From: Anita Gardner
Sent: 26 February 2018 12:27
To: Karen Parsons
Subject: FW: FW: Proposed KFC at Fontwell - LPA ref WA/88/17

1. It would appear that there are proposed extension/changes planned for the Burger King. This is shown both on the Proposed General Arrangement Plan dwg 217052-A200 and also Proposed Site Layout Plan dwg 217052 A000.

drawing no. 217052 - A200 revision

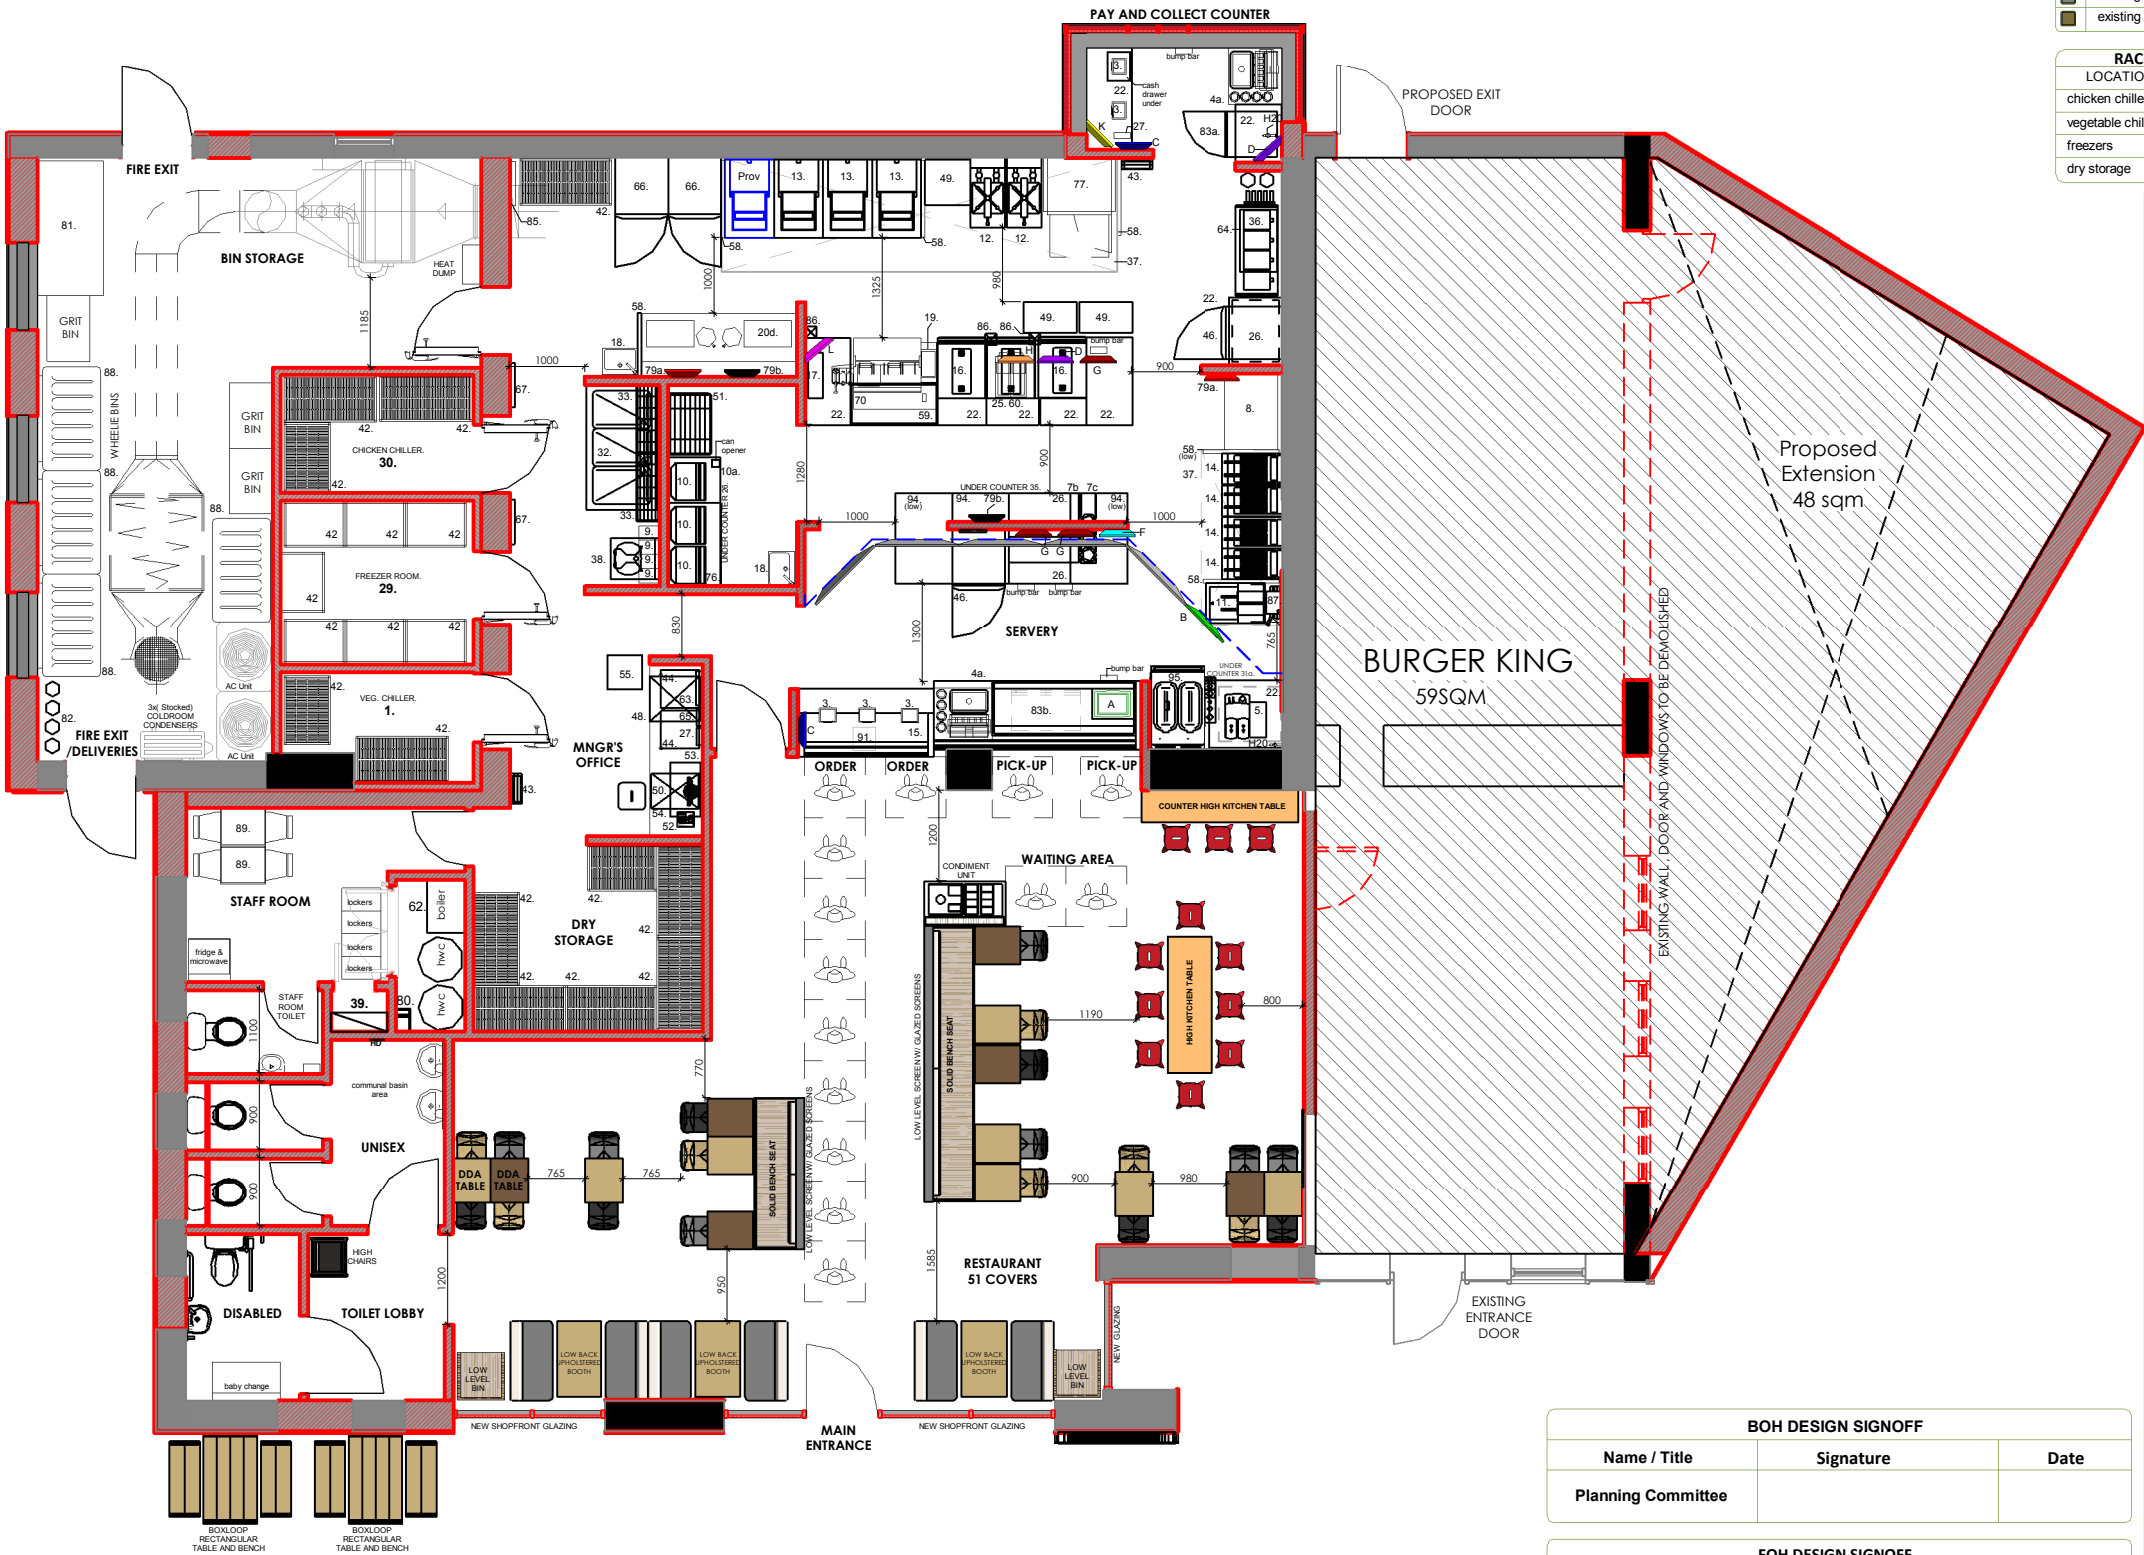
The plans do clearly refer to the proposed General Arrangement Plan and Exterior Elevations and should be deleted from the application drawings. The annotation does not state 'possible future extension which will be subject to a separate application'. It implies the extension is included. The application will need to be determined at Committee given the Objection from the Parish Council and the plans could cause confusion.

1. The application letter states "there are no proposed works to the attached Burger King unit" but the plans show a 48 sq m triangular extension. Which is correct? Is Burger King being extended or not?

As previously advised, there are no external works proposed for BK - this is clear in the application description and would be happy for an informative on the approval to ensure this point is clear

1. There are no external alterations or extensions proposed to Burger King. There may be an internal refit but no external changes are proposed
